Subject: RE: M/151/21/PL - 7 Central Drive

I have received the updated surface water drainage strategy for this site following my comments dated 18/05/2022. Obafemi Okusipe is still listed as the Planning Officer, however, I am aware he no longer works for us.

SURFACE WATER DRAINAGE STRATEGY					
DRAWN	ENGINEER	CHECKED	APPROVED		
CS	C SLADE	LH	CS		
DATE	MARCH 22		SCALE @ A1	1:100	
JOB No.	STATUS	DRAWING No.	REV.		
100	PL	100	P2

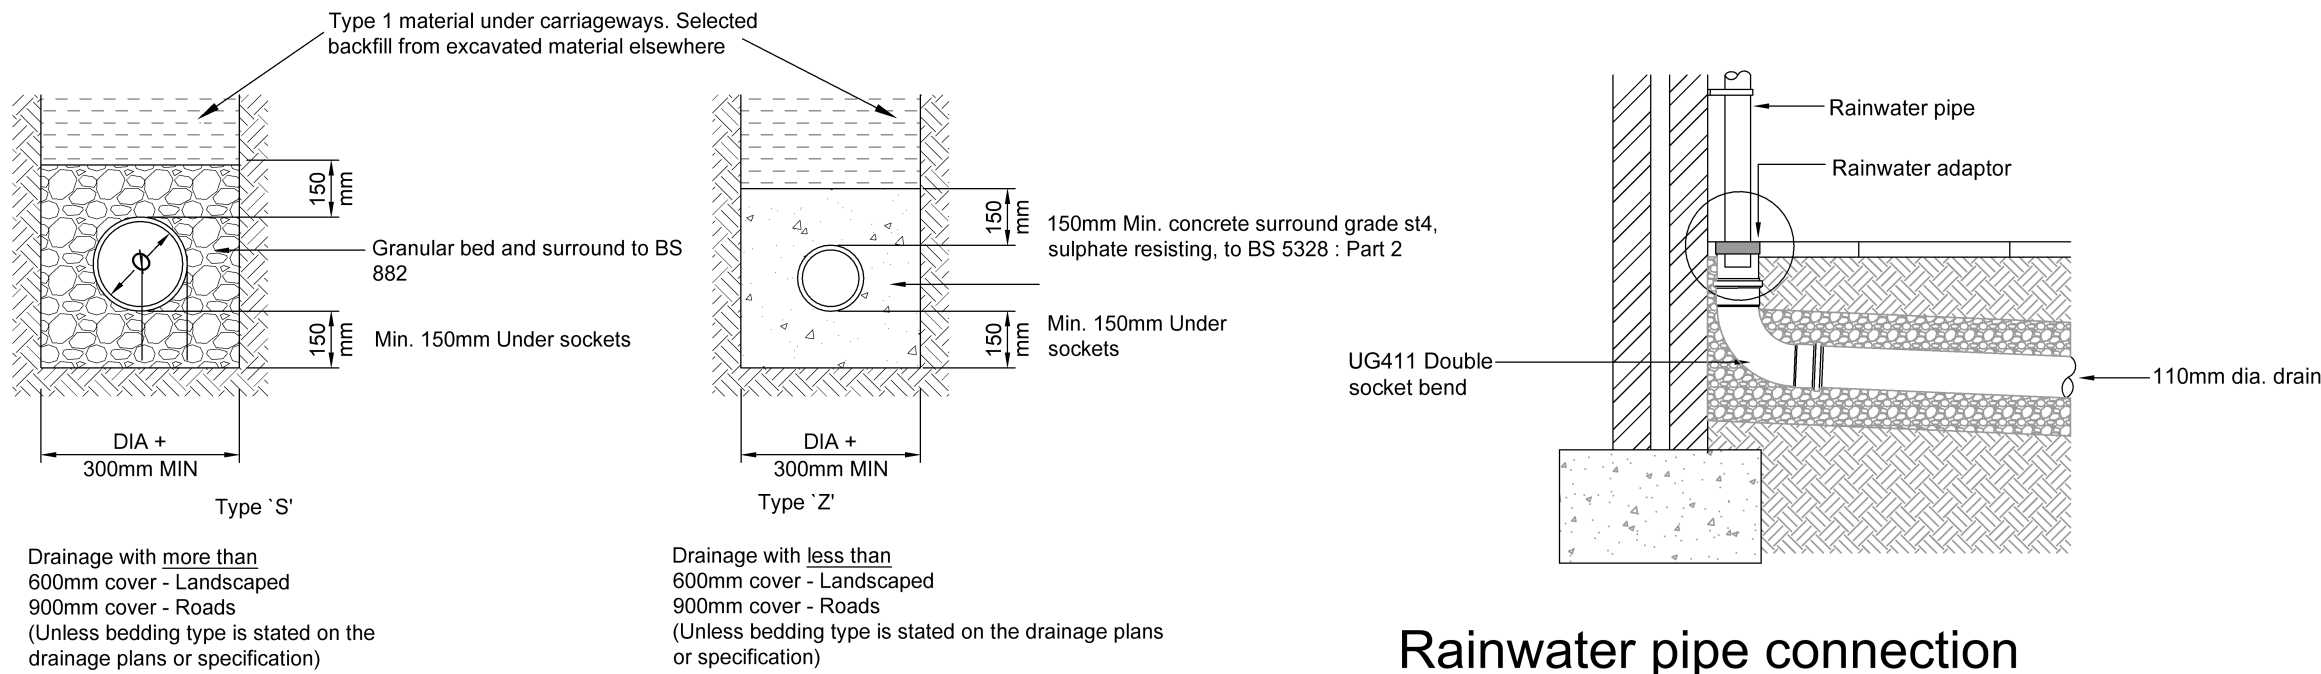
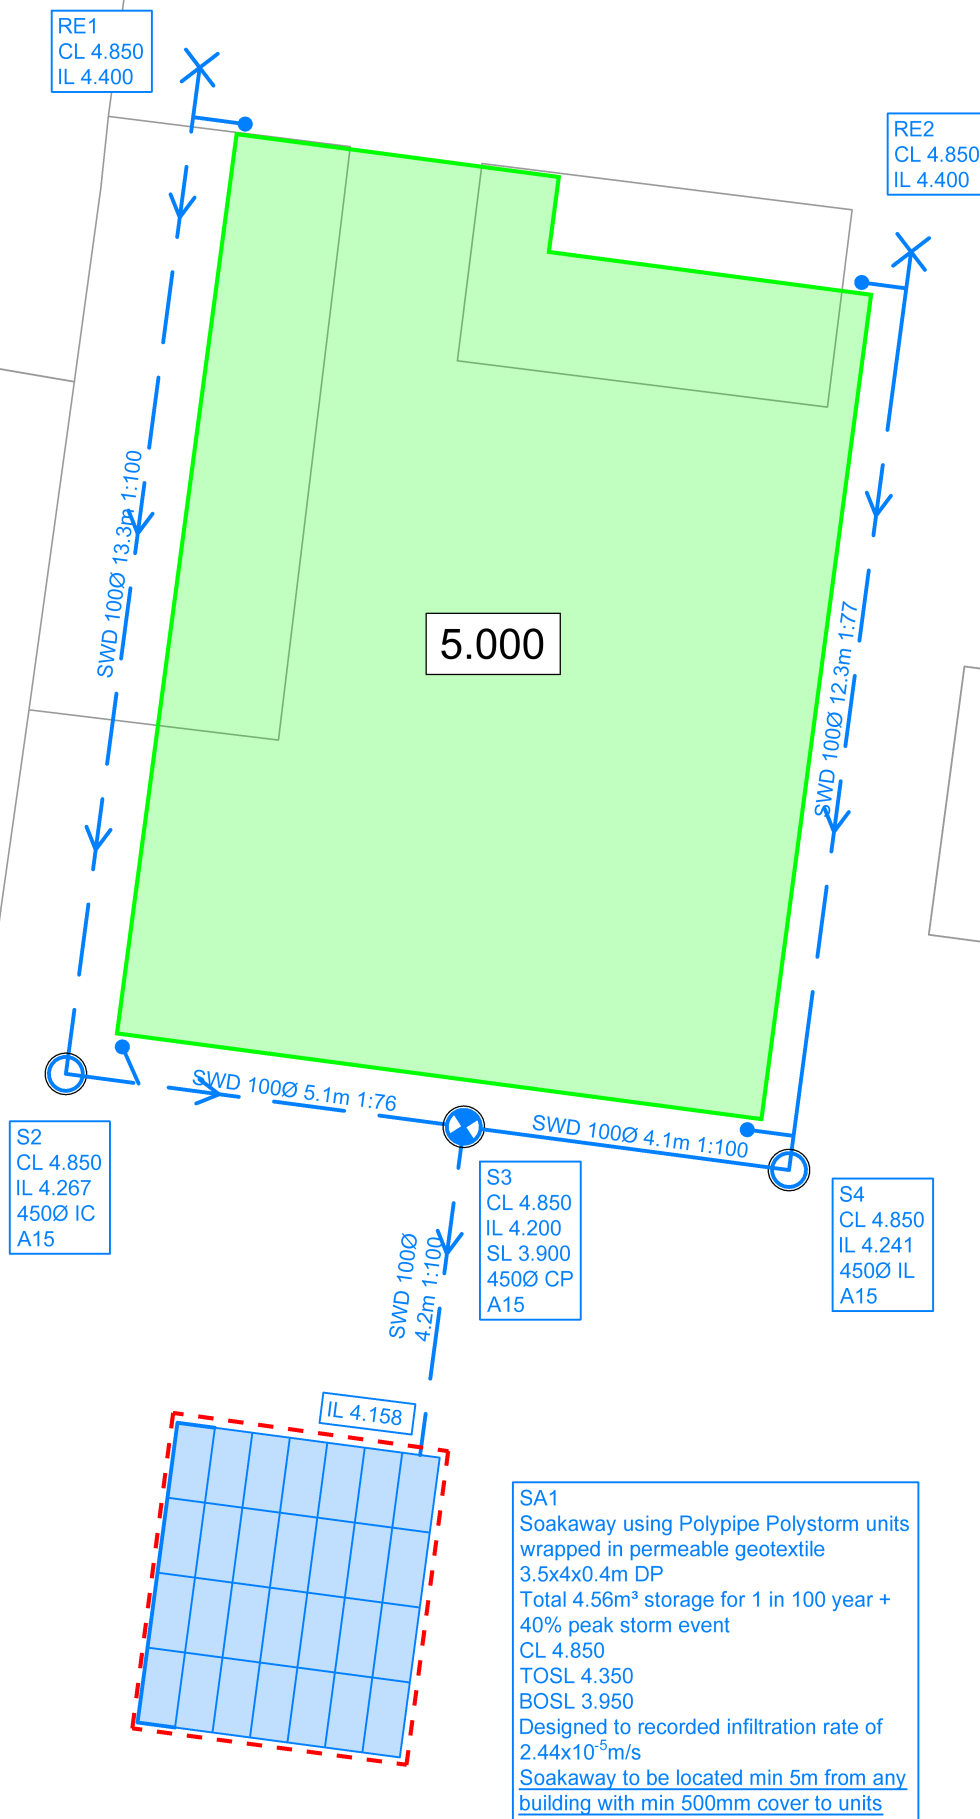
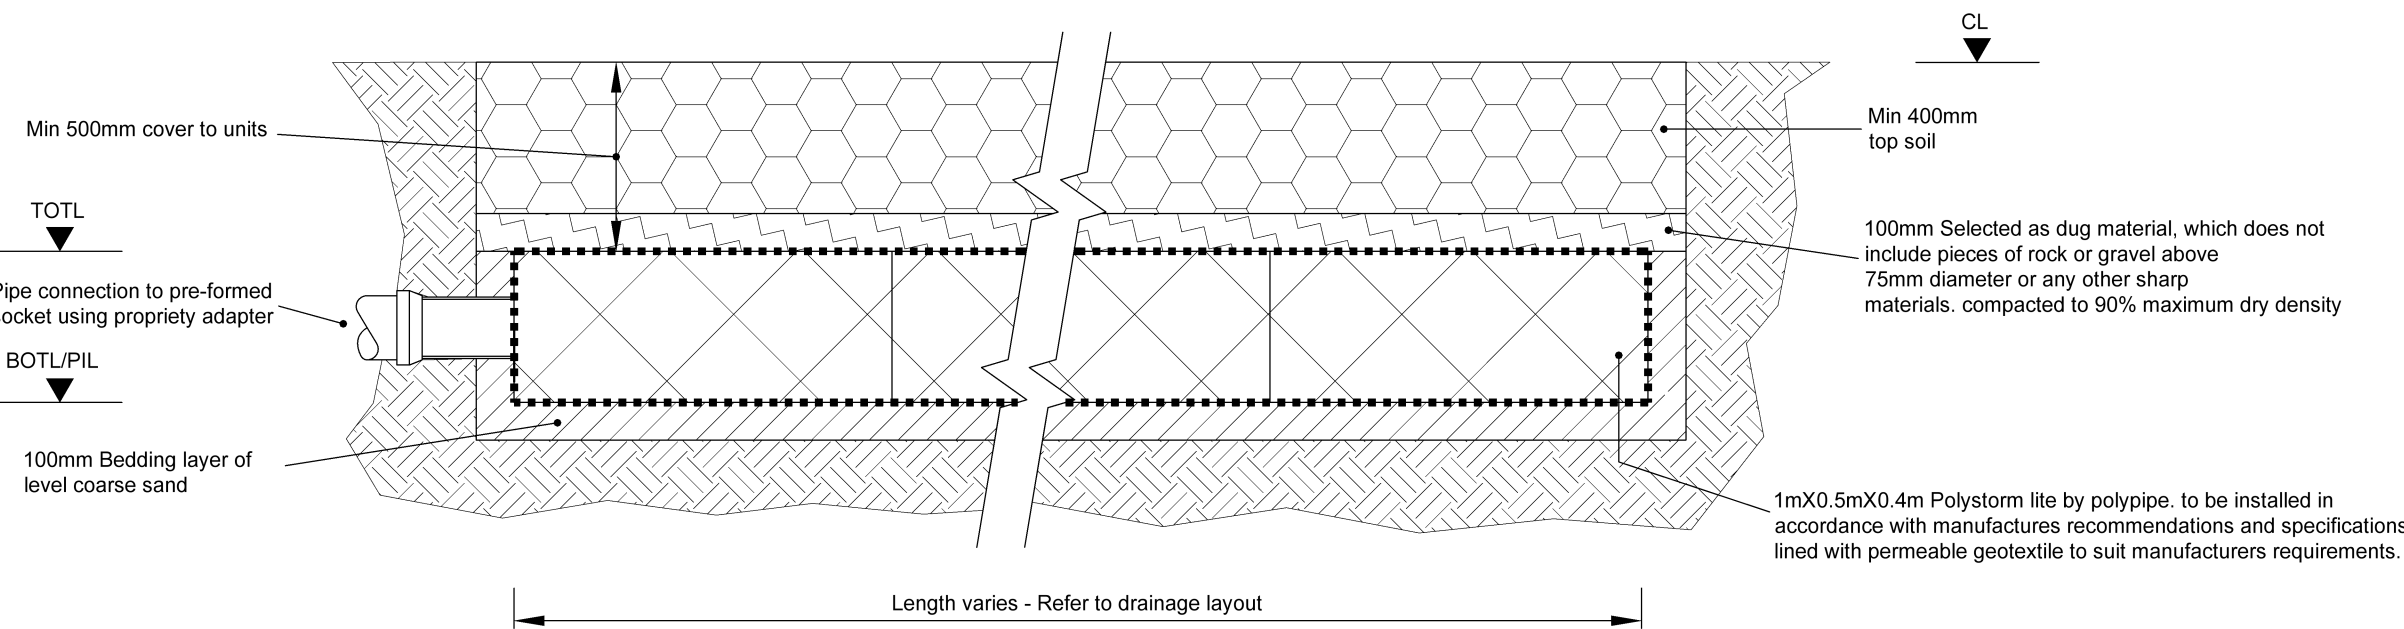
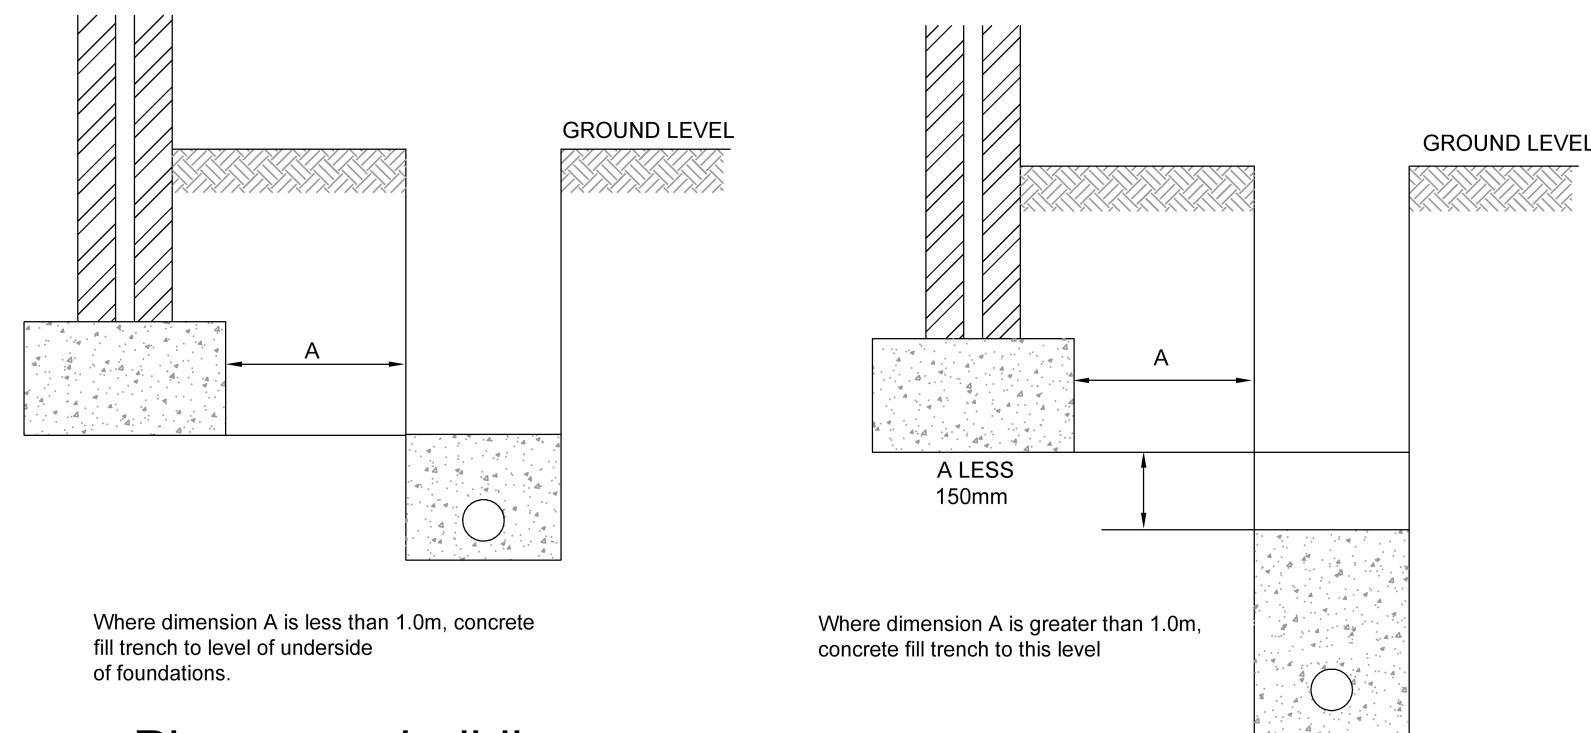
I am satisfied that most of my previous comments have been cleared, however, I think there may have been some confusion on my first one. I requested that the soakaway we located at least 2.5m from the boundary, referring to the eastern boundary with 7 Central Drive. The soakaway location has been adjusted, but it is now less than 5m (2.7m) from the proposed dwelling which is inappropriate. I can only assume the consultant thought that the 2.5m easement from the boundary referred to the dwelling as well. For clarity, the proposed soakaway must be located at least 5m from the proposed dwelling and at least 2.5m from the property boundaries.

Many thanks for bringing this to my attention. We will make the quick adjustment and have a revised drawing issued.
